# Steeple Renewables Project

## Applicant Comments on Deadline 2 Submissions

Document Reference: EN010163/EX/8.24

VIEWPOINT 18A

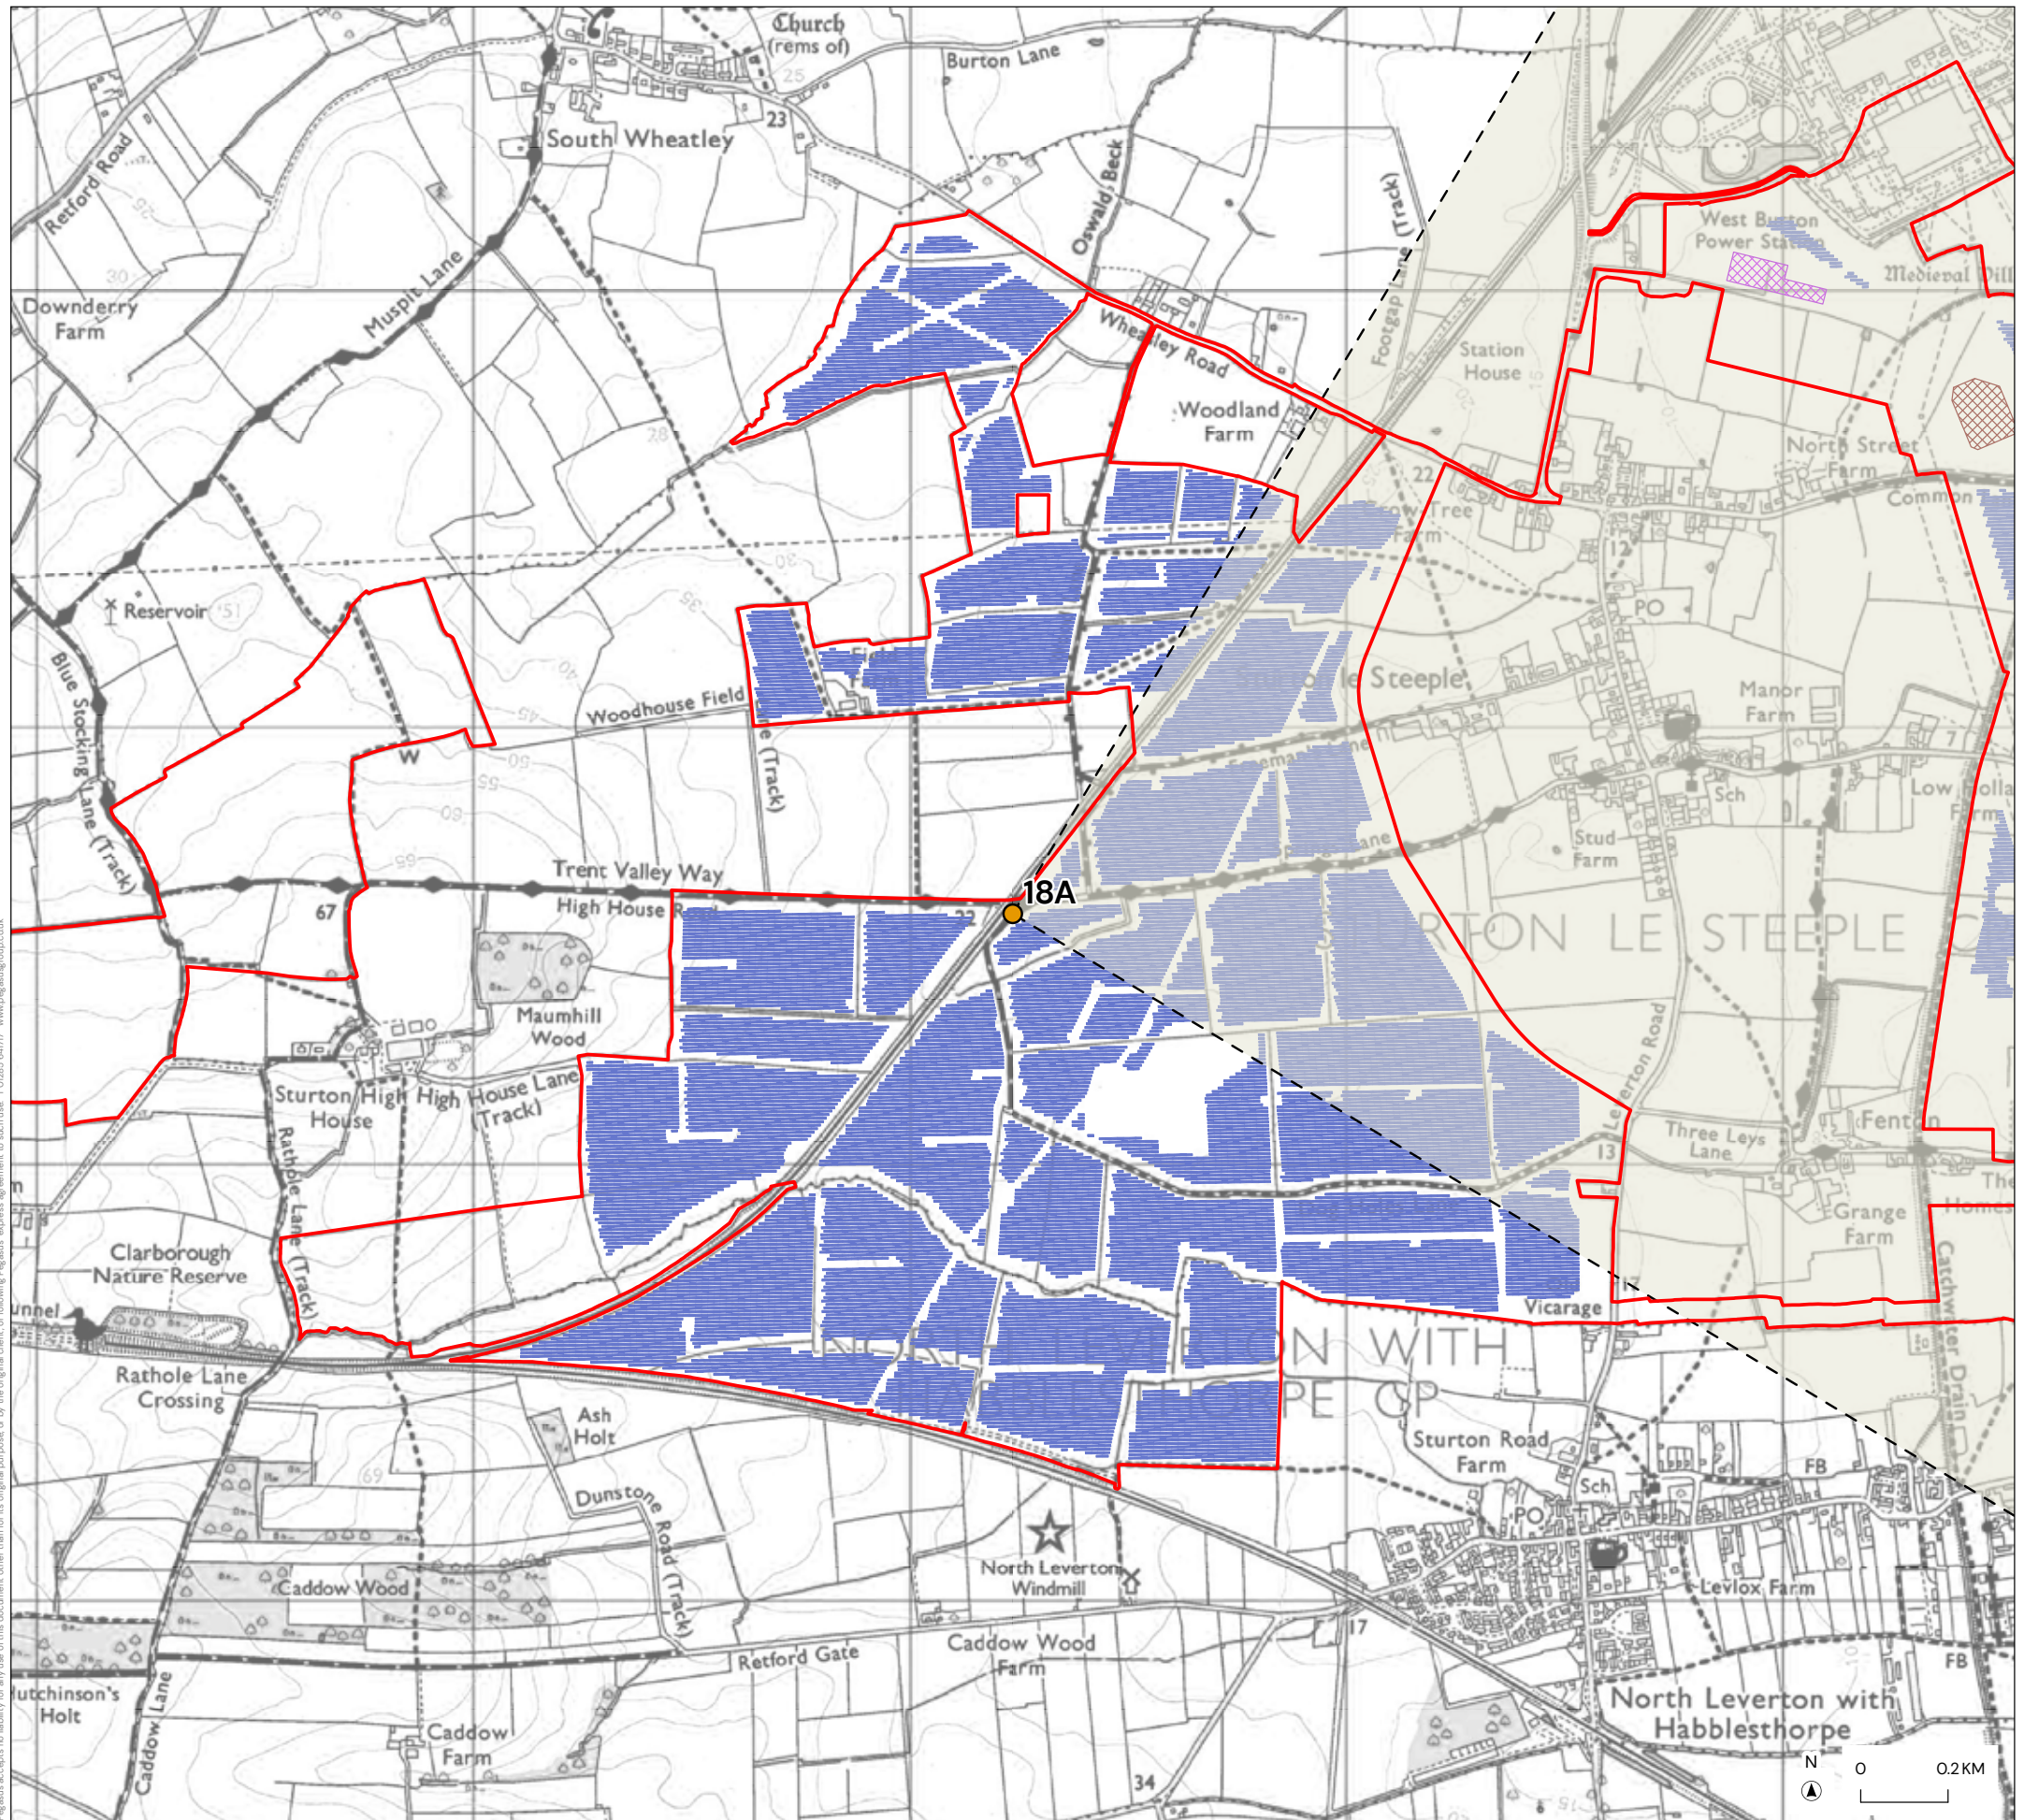
<p>embankments. We agree that more visually exposed locations of the High House Road / Trent Valley Way need to be used. We would suggest that Viewpoint 18 is an exception rather than the rule and should be relocated to an appendix. We agree with the ExA's requested additional viewpoint locations on Trent Valley Way as described in Q13.0.3.</p> <p><b>No clear methodology</b> for the visualisations is provided in the LVIA and more information on this could be provided (refer paragraph 5.5).</p> <p>There was prolonged discussion at the Hearing regarding why Viewpoint 18 – Sheet A – High House Road / Trent Valley Way had been selected. It was felt that this viewpoint did not provide a 'worst case' view of the proposed development.</p> <p>Viewpoint 18 was taken from a railway underpass and views are contained by the location's low elevation and raised embankments. We agree that more visually exposed locations of the High House Road / Trent Valley Way need to be used. We would suggest that Viewpoint 18 an exception rather than the rule and should be relocated to an appendix. We agree with the ExA's requested additional viewpoint locations on Trent Valley Way as described in Q13.0.3.</p>	<p>regarding growth rates which were used in the production of the visualisations, this was addressed at paragraphs 6.8.6 and 6.8.7 of the LVIA Chapter.</p> <p>It appears the same point has been repeated regarding Viewpoint 18 at the end of this section. This is therefore covered by the Applicants response previously provided above.</p>
